# EL PASO COUNTY PLANNING AND COMMUNITY DEVELOPMENT DEPARTMENT

## GRADING AND EROSION CONTROL PLAN CHECKLIST ROLLING HILLS RANCH FILING 2

ROLLING HILLS RANCH FILING 2  
AT MERIDIAN RANCH  
GRADING/EROSION CONTROL PLAN  
GRADING LAYOUT

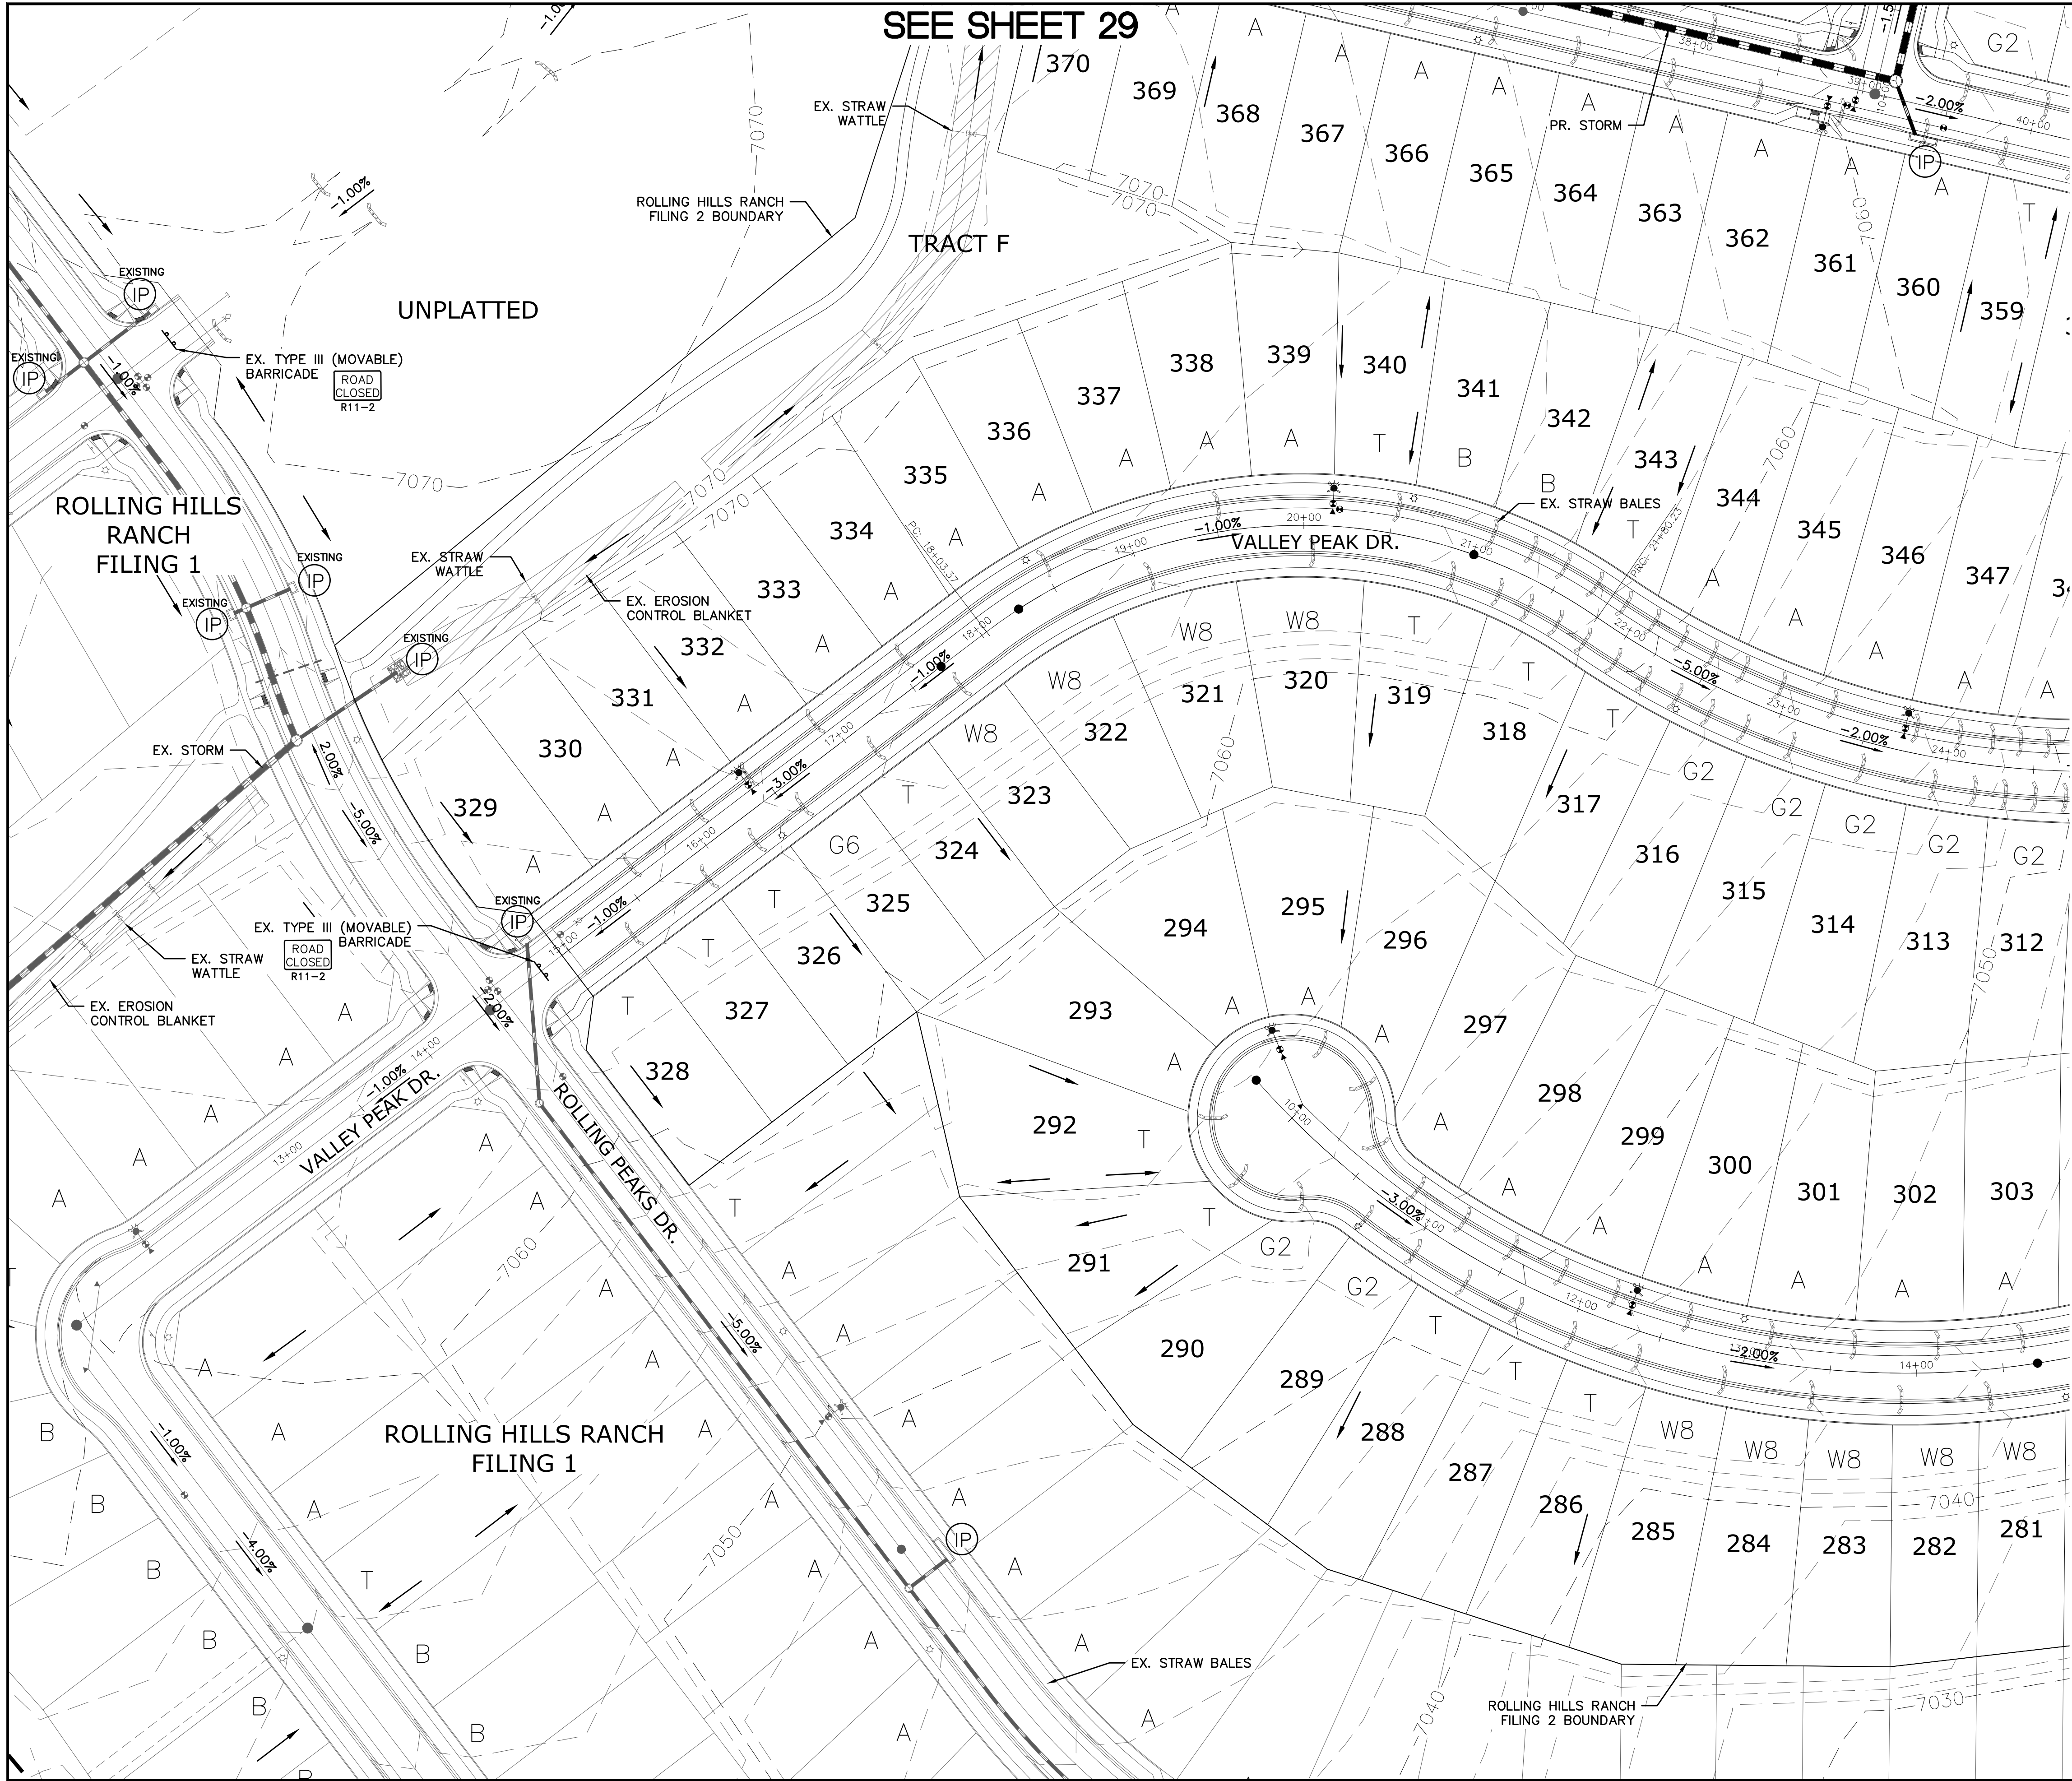
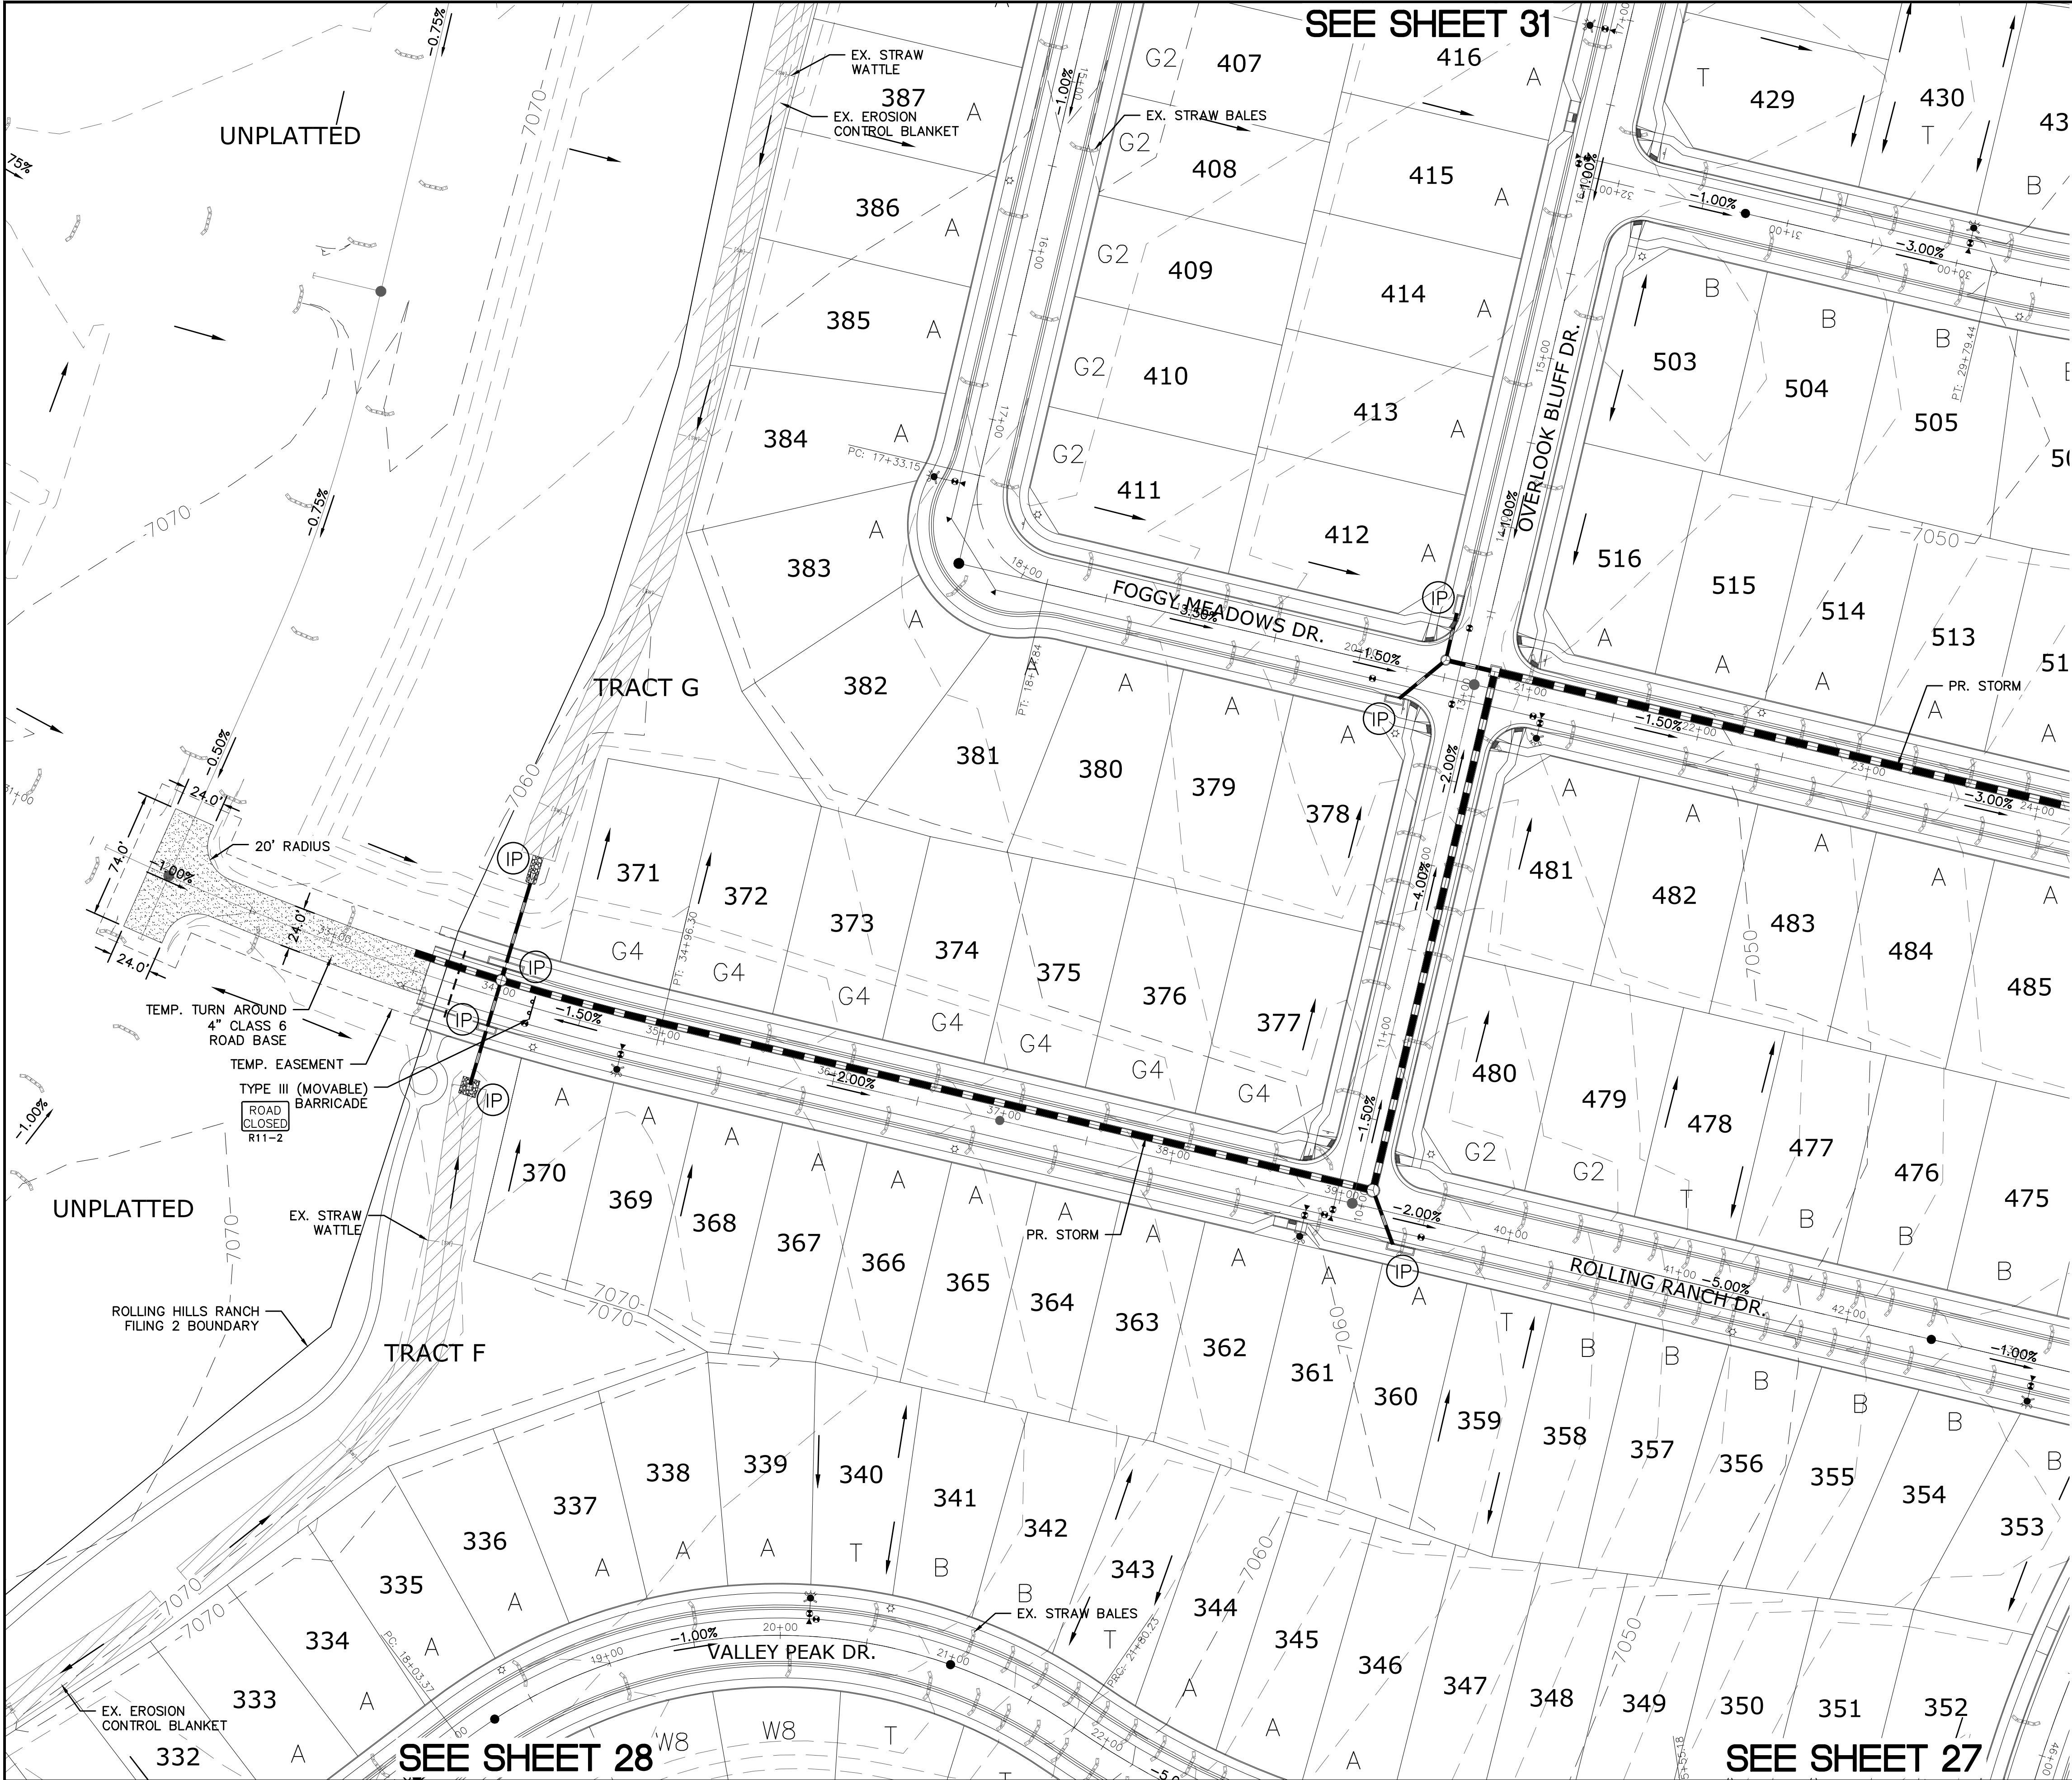
v	All proposed temporary construction control measures, structural and non-structural. Temporary construction control measures shall be identified by phase of implementation to include "initial," "interim," and "final" or shown on separate phased maps identifying each phase. Revised	✗	✗
w	Vehicle tracking provided at all construction entrances/exits. Construction fencing, barricades, and/or signage provided at access points not to be used for construction.	✗	✓
x	Temporary sediment ponds provided for disturbed drainage areas greater than 1 acre.	n/a	N/A
y	Dewatering operations to include locations of diversion, pump and discharge(s) as anticipated at time of design.	n/a	N/A
z	All proposed temporary construction control measure details. Custom or other jurisdiction's details used must meet or exceed EPC standards.	✗	✓
